# DESIGN COLLABORATIVE Pty Limited

28 May 2025  
Ref: 252145.2L

Submission on behalf of the Owners' Corporations of 'Metro Residences' – 'Metro View' (SP 88677) at 69 Albert St, 'Metro Spire' (SP 88678) at 1 Post Office Lane and 'Metro Grand' (SP 88679) at 438 Victoria Avenue, Chatswood – SSD-63324208 410-416 Victoria Avenue, Chatswood – Construction of a build to rent (BTR) development with ground and first floor retail premises, 260 BTR units, communal facilities and 3 levels of basement

SHADOW DIAGRAMS

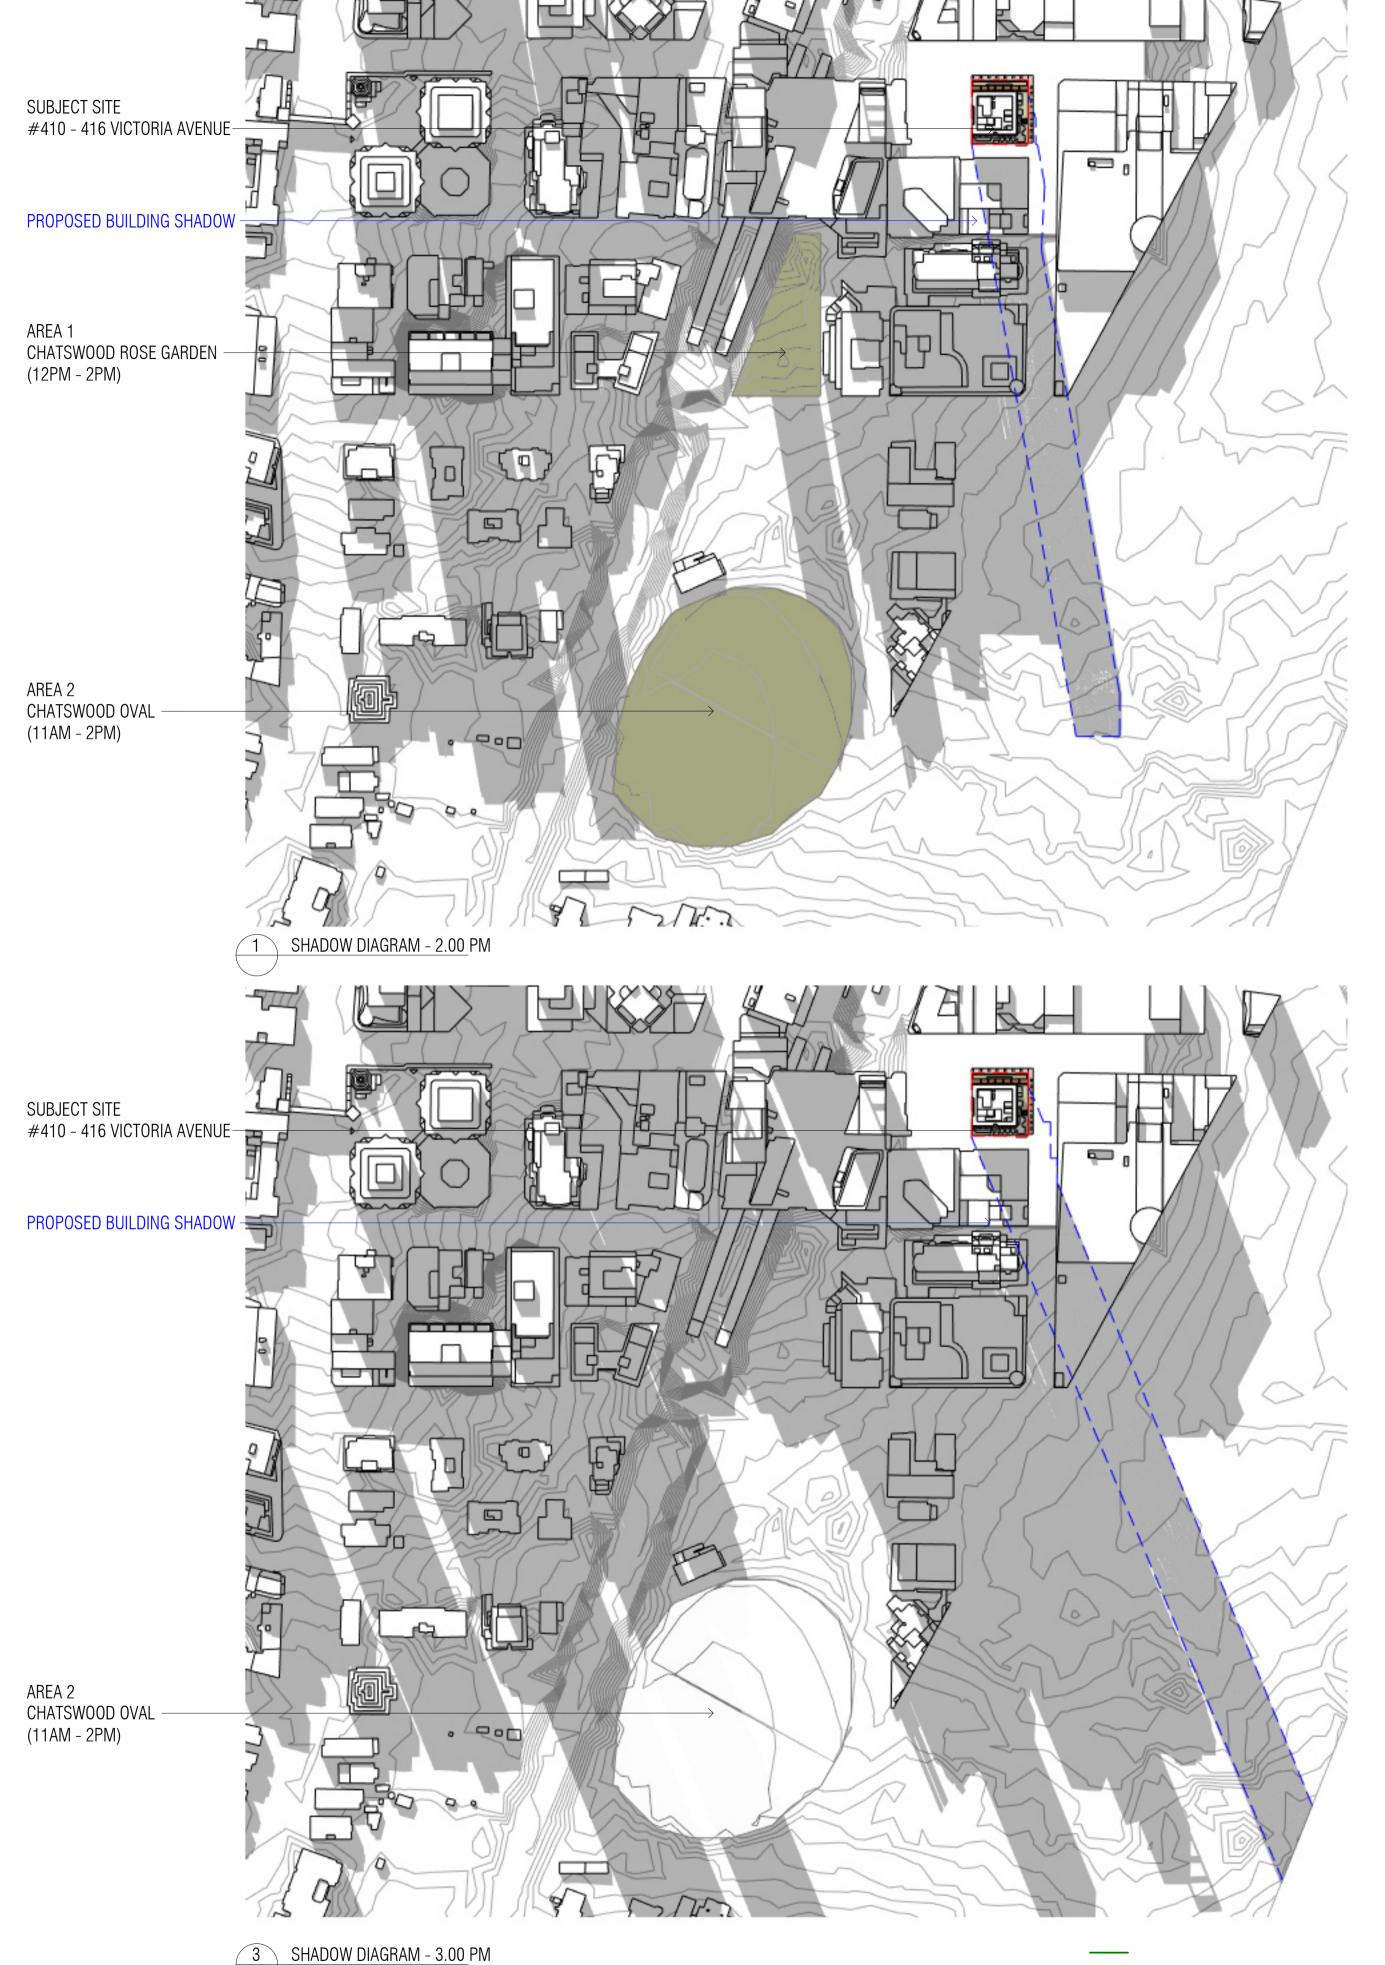
The proposal will result in additional overshadowing of Metro Spire and Metro View as shown in the midwinter shadow diagrams and 'Sun Eye View' diagrams from the EIS (p. 93)/architectural plans (see **Figures 2** and **3**).

The proposed SSD will have a significant adverse impact on the level of solar access achieved to the south-east-facing units in Metro View. The level of impact is such that these units will not achieve 2 hours solar access in accordance with the criteria under the ADG.

As shown above, at 9am and 10am, the proposal will overshadow most of the eastern façade of Metro View. At 9am, solar access is retained only to the SE corner of the building. At 10am, solar access is retained to the northern elevation/NE corner. This level of impact represents a significant and marked reduction in solar access to these units compared with the existing situation.

At 11am, the diagrams show there is no direct impact on Metro View and solar access is achieved to the eastern façade.

However, at 12 noon, due to the angle of the façade, the diagrams show that solar access would not be achieved to the south-east-facing units in Metro View.

Accordingly, the proposal will reduce the solar access of south-east-facing units in View such that they would not achieve the required 2 hours at mid-winter to living rooms/private open space. The 'as built' plans of Metro View indicate that there are units with living rooms and private open space at Levels 5-31 which would be adversely affected by this loss (see **Figure 4**). This will result in a significant loss of amenity to these units which currently achieve 2+ hours solar access throughout the morning.

It is submitted that the proposed development should be amended through provision of greater setbacks to the proposed tower to reduce its bulk so that the south-east-facing units in View achieve the minimum 2 hours solar access to living rooms/private open space. In addition, the assessment of compliance and impact should be revised and based on the actual unit layout within each of the buildings rather than on the basis of 'facades'. Without such an assessment the conclusions reached in the submitted SSD documentation cannot be relied upon.

As shown in the diagrams above, at 9am, the proposal will overshadow the SE corner of Metro Spire. By 10am, Metro Spire is not overshadowed. This overshadowing would affect the SE corner living rooms/wintergardens of units at each level of the building but is considered minor.
